**re: Grading & Site Servicing Plan Review**  
Proposed Multi-Storey Building  
1815 Montreal Road – Ottawa, Ontario

**date: October 20, 2023**

**file: PG6594-MEMO.02**

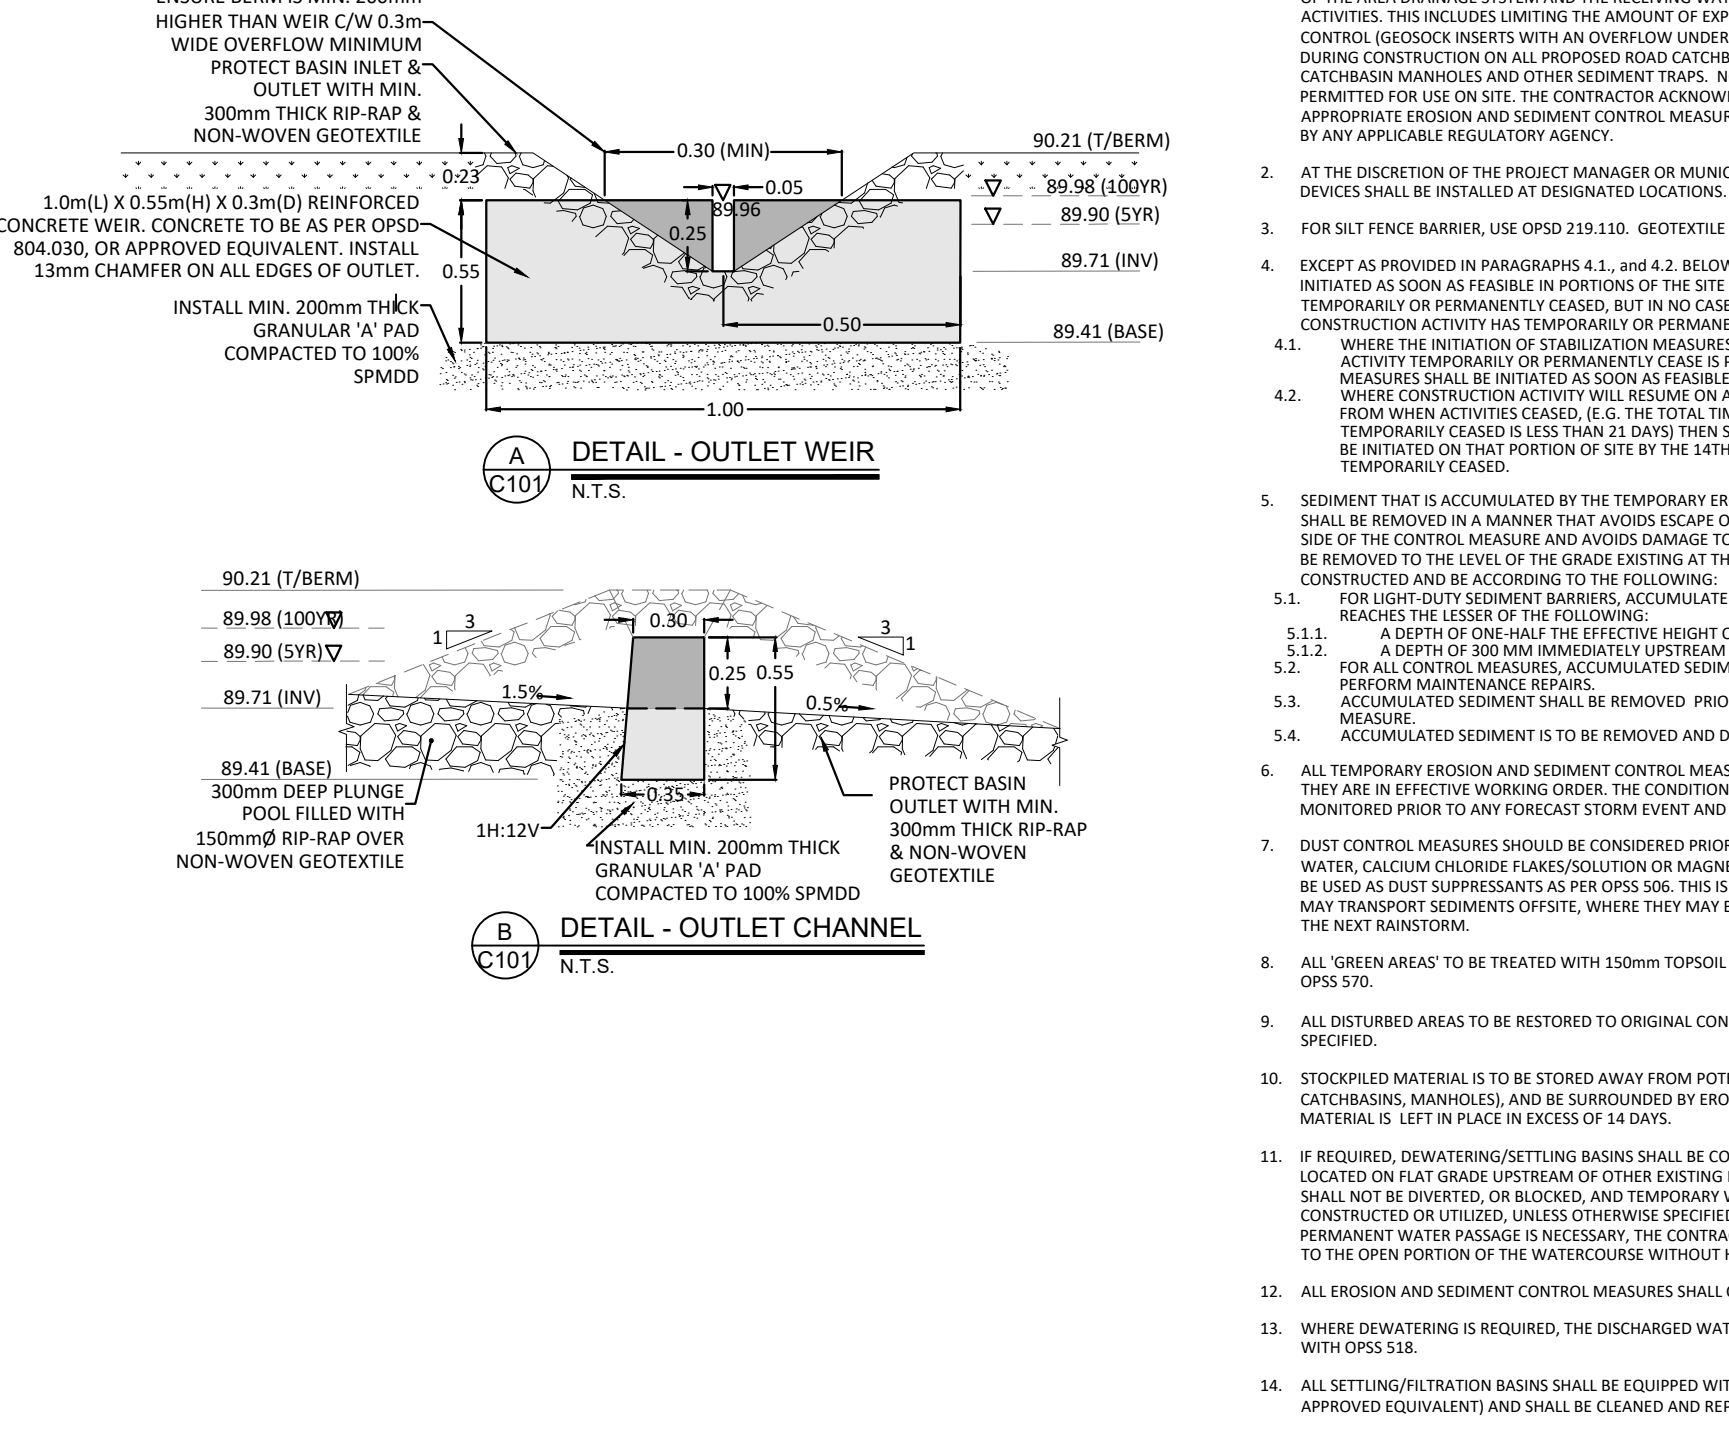
Due to the presence of the silty clay deposit at the site, a permissible grade raise restriction of 2 m was recommended for grading at the subject site. Based on our review of the grading plan, significant grade raise exceedances of approximately 2 to 2.5 m above the permissible grade raise restriction are proposed. As such, lightweight fill, such as expanded polystyrene (EPS) geofoam blocks, are recommended adjacent to the proposed building, retaining wall and other settlement structures, where grade raise exceedances are proposed, for the portion of the grade raise exceeding 2 m. Please refer to Figure 1 – Grading Plan Review, attached to the current memorandum, for the approximate limits of where lightweight fill (LWF) is required.

Based on our review of the site servicing plan, sufficient soil cover has been provided to the proposed watermain and sanitary services. However, insufficient soil cover was noted along segments of the proposed stormwater service. Where insufficient soil cover (i.e. less than 2.1 m of soil cover is present above the obvert of the pipe) is available, the following frost protection criteria outlined in Table 1 should be followed. Please refer to Figure 2 – Site Servicing Plan Review attached which indicates the frost protection provided to each service.

<b>Table 1 - Rigid Insulation Recommendations for Storm Sewer and Water Pipes with Reduced Soil Cover</b>			
<b>Thermal Condition</b>	<b>Soil Cover Provided (mm)</b>	<b>Insulation Dimensions</b>	
		<b>Thickness (mm)</b>	<b>Extension (mm)</b>
Unheated	600 to 900	125	Extend 1200 mm horizontally beyond edge face of the pipe
	900 to 1200	100	Extend 1200 mm horizontally beyond edge face of the pipe
	1200 to 1500	75	Extend 900 mm horizontally beyond edge face of the pipe
	1500 to 1800	50	Extend 600 mm horizontally beyond edge face of the pipe
	1800 to <2100	25	Extend 300 mm horizontally beyond edge face of the pipe
